**MEMORANDUM**

Add PCD File #  
PPR-2315

Re: Super Star Car Wash (Claremont Business Park 2) Traffic Compliance Letter

C3.1

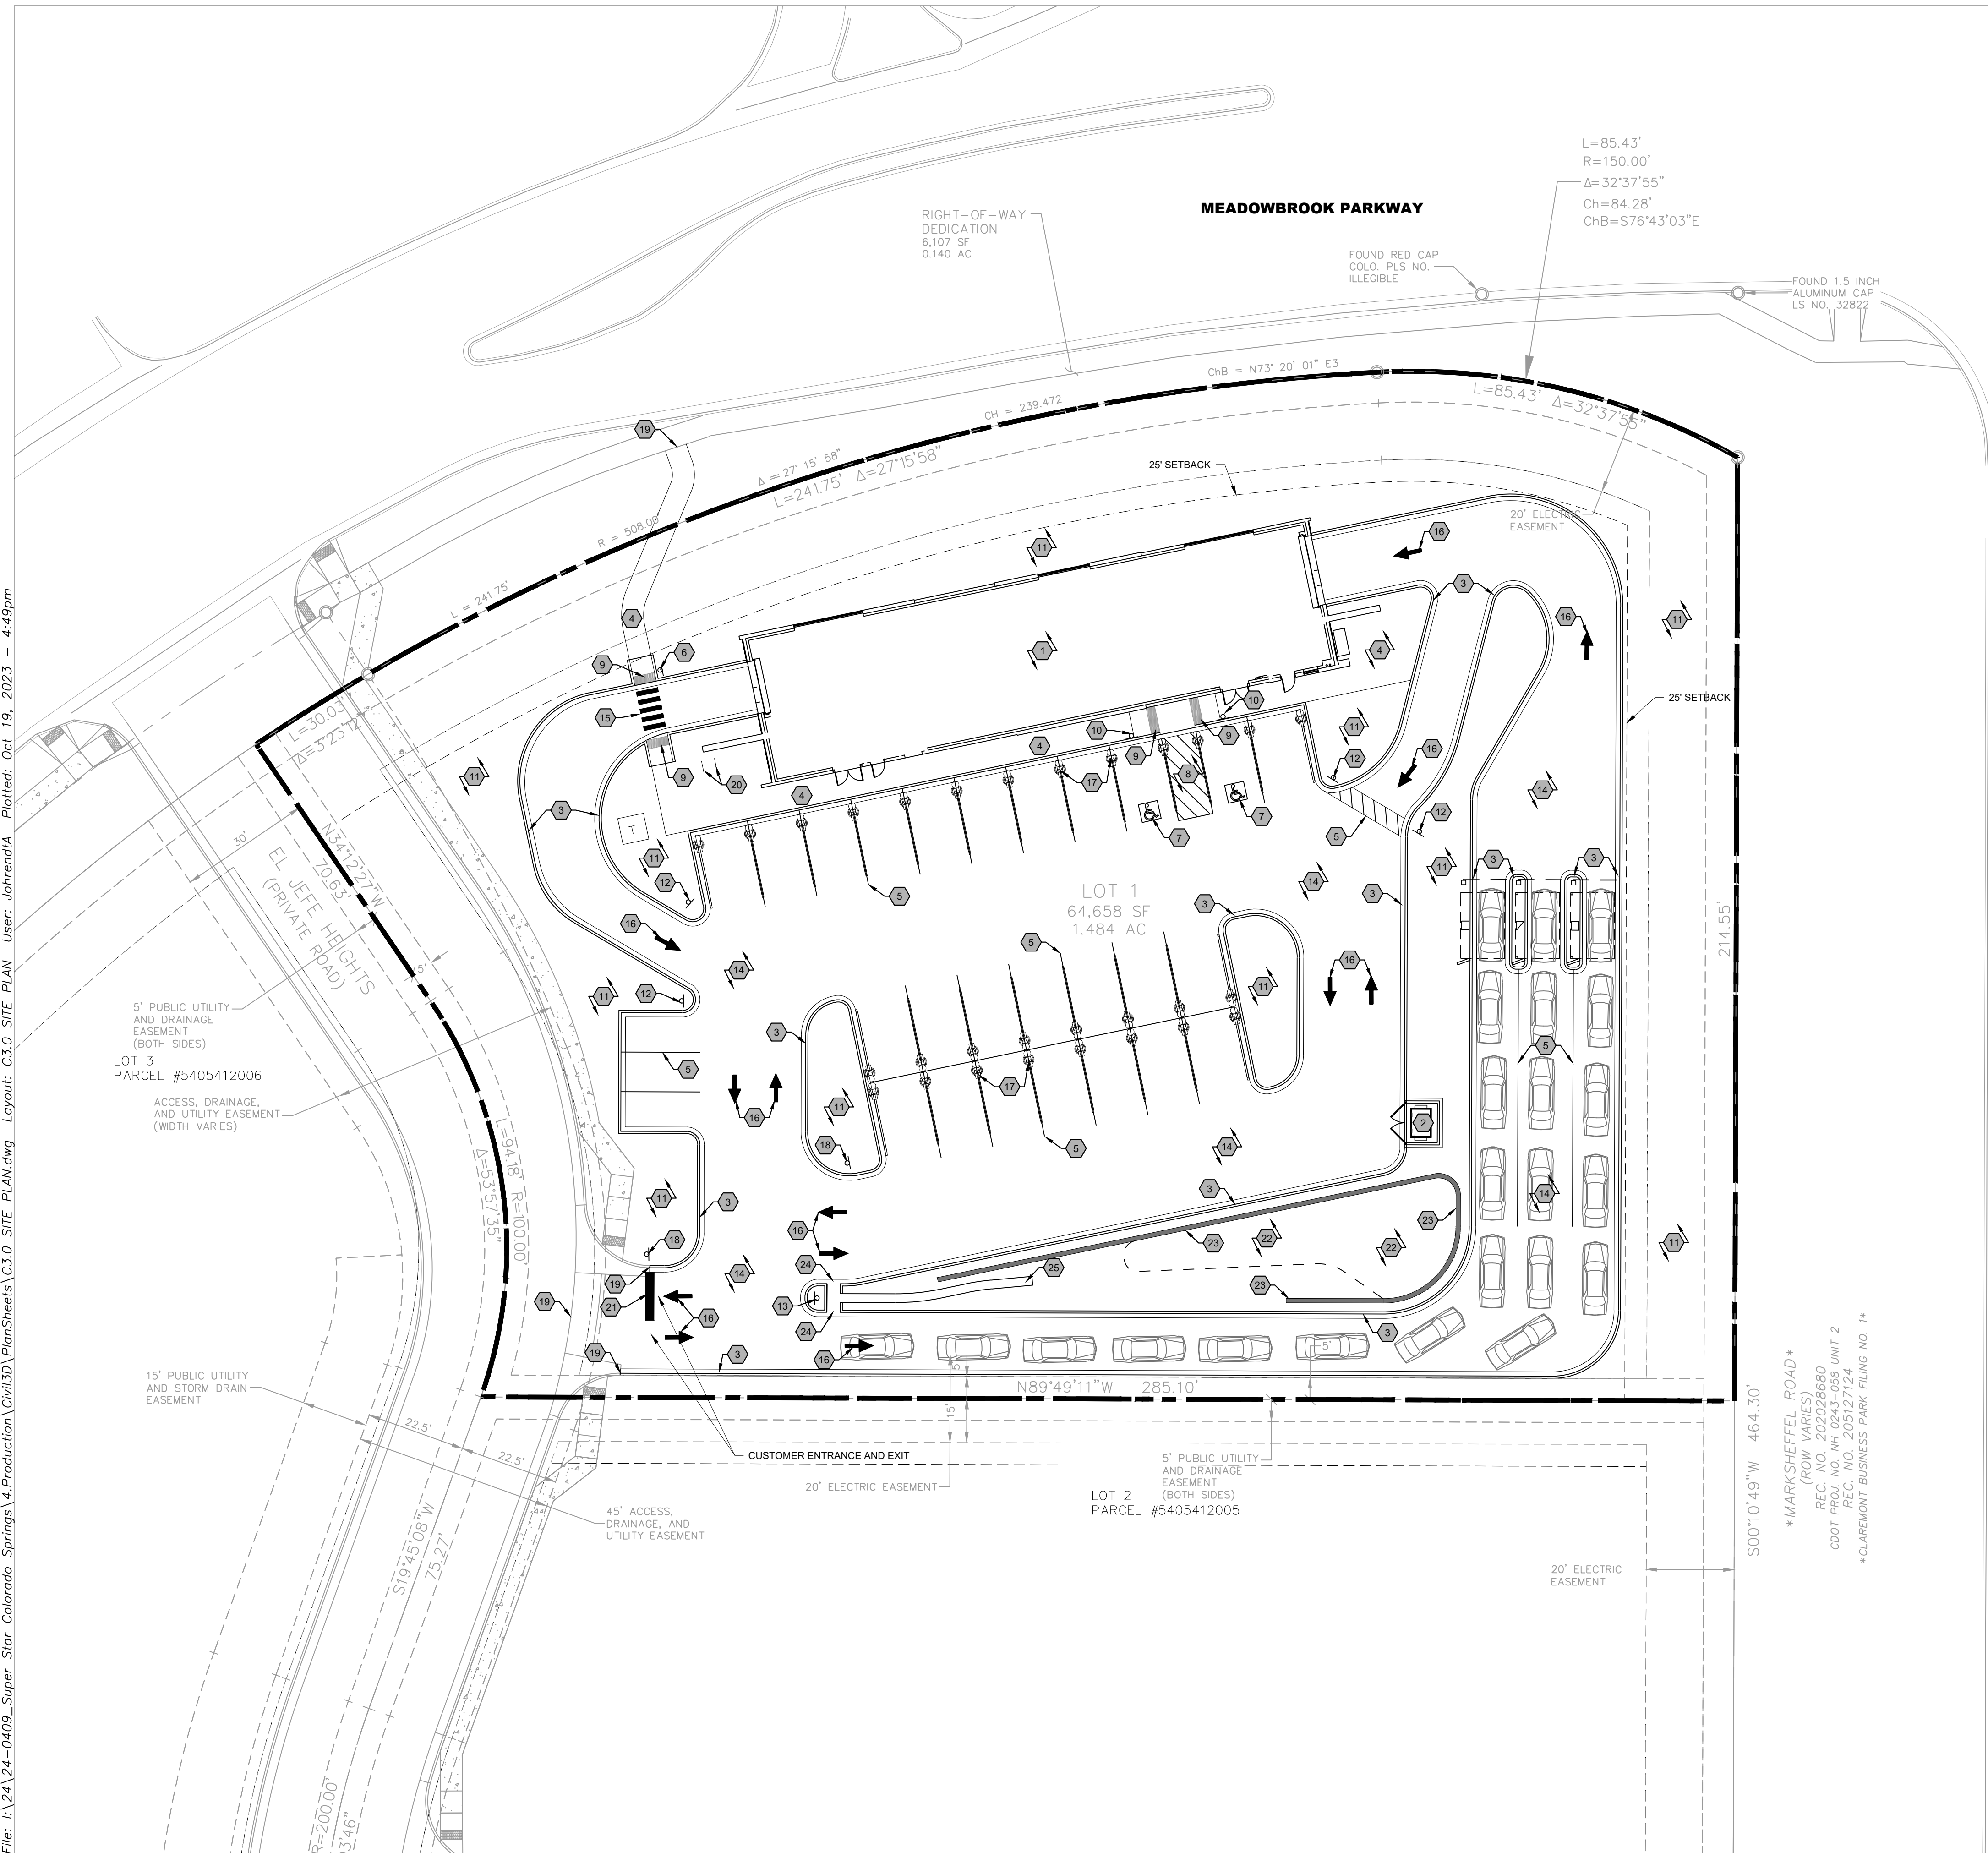
Provide analysis of the proposed access to El Jefe Heights. Identify whether any Aux. turn lanes are needed on El Jefe Heights into this driveway due to this developments traffic. Analyze the queuing to get into the site and the potential to back up into Meadowbrook parkway.

Provide line of sight analysis for driveway entrance into car wash from El Jefe Height. Utilize appropriate size truck and sight distance for road class in the commercial business/industrial use park area. State what the sight distance is for every affected access and whether it can be met. If it cannot be met, state the required modifications so that it can be met.
